## Building Inspections - 550 Warren Ave new application submittal former Jokers

**From:** Jeanie Bourke  
**To:** buildinginspections@portlandmaine.gov  
**Date:** 9/12/2014 3:46 PM  
**Subject:** 550 Warren Ave new application submittal former Jokers  
**CC:** Tammy Munson  
**Attachments:** Fitness Equipment Layout.pdf; Backup Files.pdf; Elevation Plan.pdf; Existing Plan.pdf; Plot Plan.pdf; Proposed New Plan.pdf; Reflective Ceiling Plan.pdf; Wall Partition.pdf; Fitness Factory Building Application.PDF; email reply for preliminary review and intake.pdf

As far as the 8 things you asked me to submit.

PRELIMINARY LIFE SAFETY PLAN

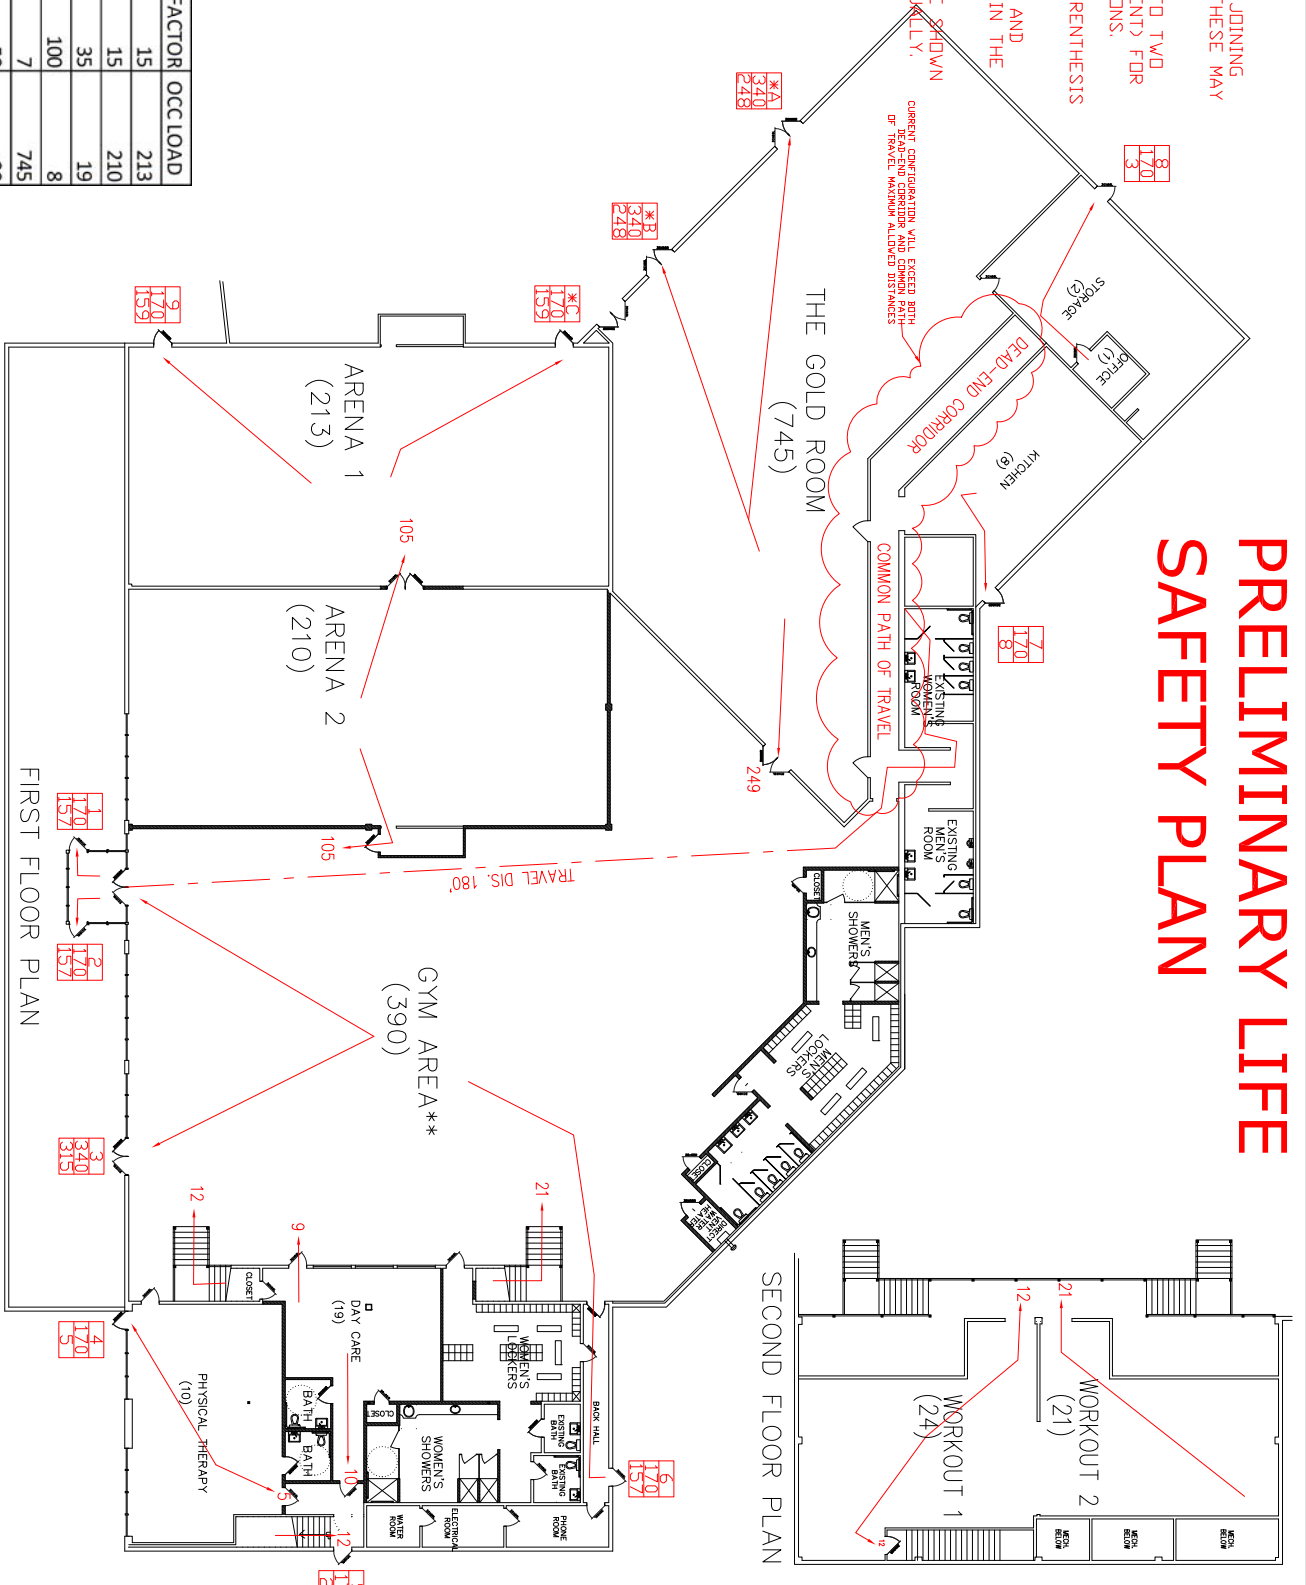
**3. Provide a (For Construction rather than Preliminary) compliant Life Safety plan, this plan shows dead end and common path of travel issues. Please address these and re-submit.**

I was told originally that the prelim one we sent was good enough to start moving forward. Carol has committed to finishing this for us and I am confident it will be more than acceptable she just can't do this for at least a week.

FLOOR PLAN
PORTLAND SPORTS CENTER
WARREN AVENUE PORTLAND, MAINE

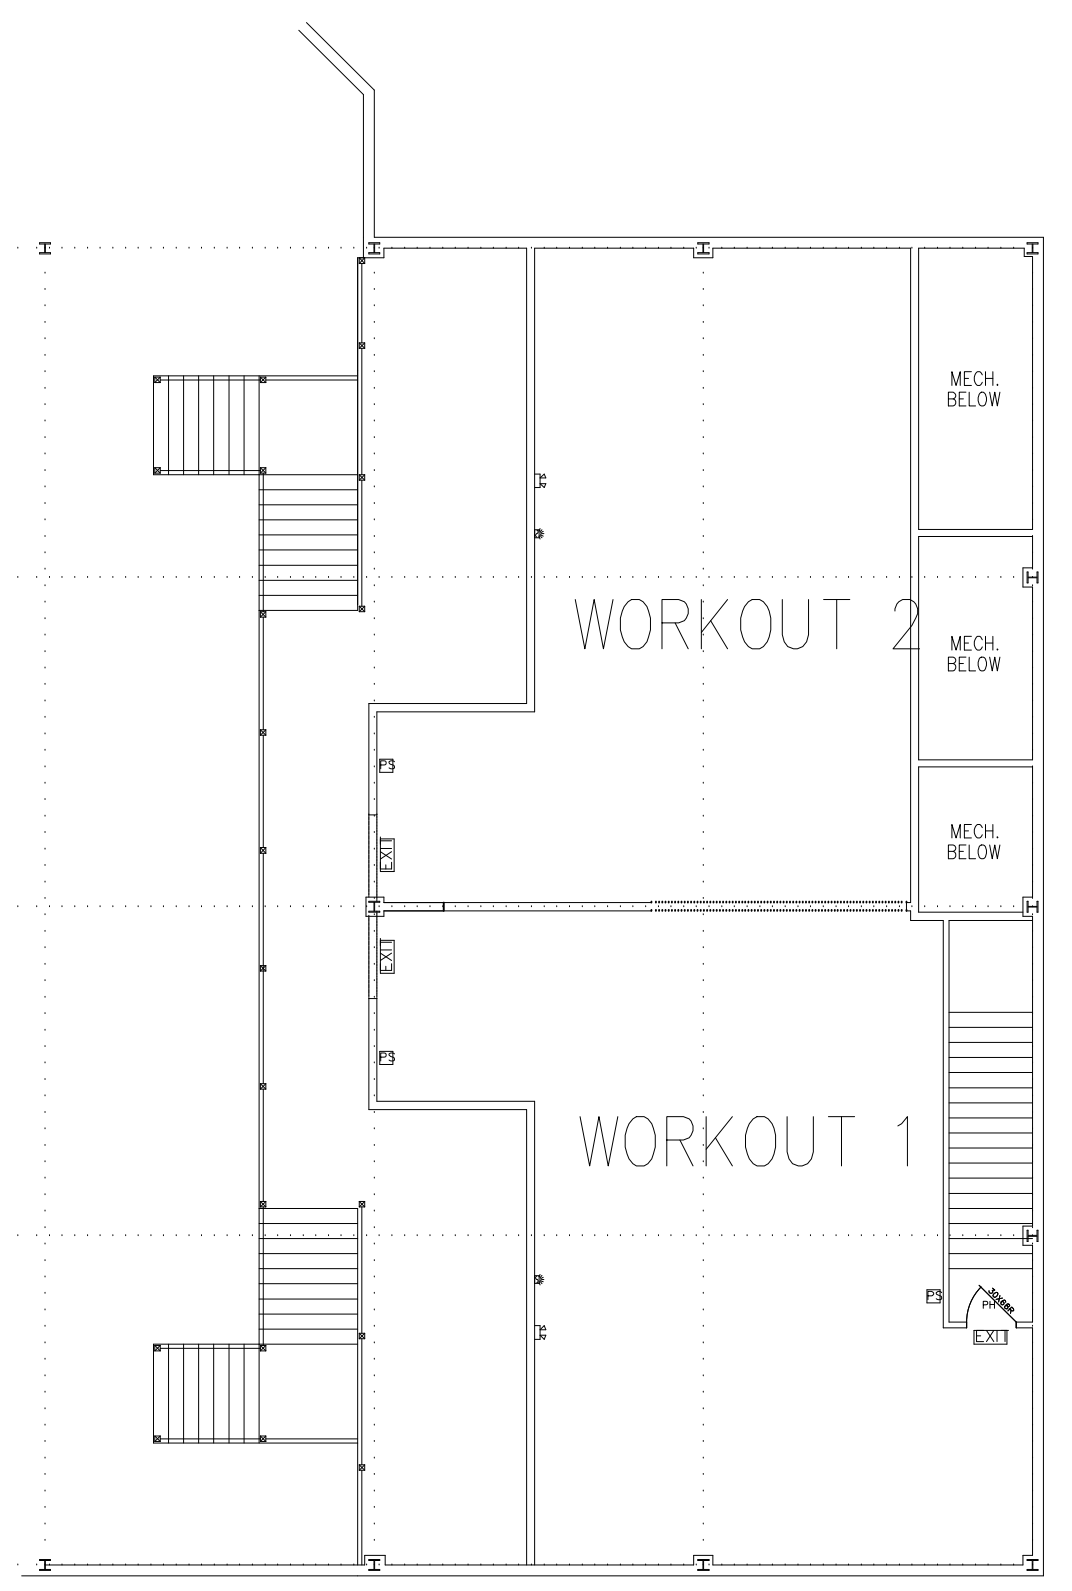
**4. On the pdf file plan, Wall Partition, please provide a section with the head of wall detail. This will clarify the ceiling type, ie. drop in ACT, hard ceiling or alternate design. There may be more than one wall detail, ie. the area under the existing mezzanine and the new men's locker area**

**7. On the CAD drawing provide the location of the Drinking Fountain**

We have resubmitted these and hopefully they are to your standards.

We have submitted the drinking fountains on the plans
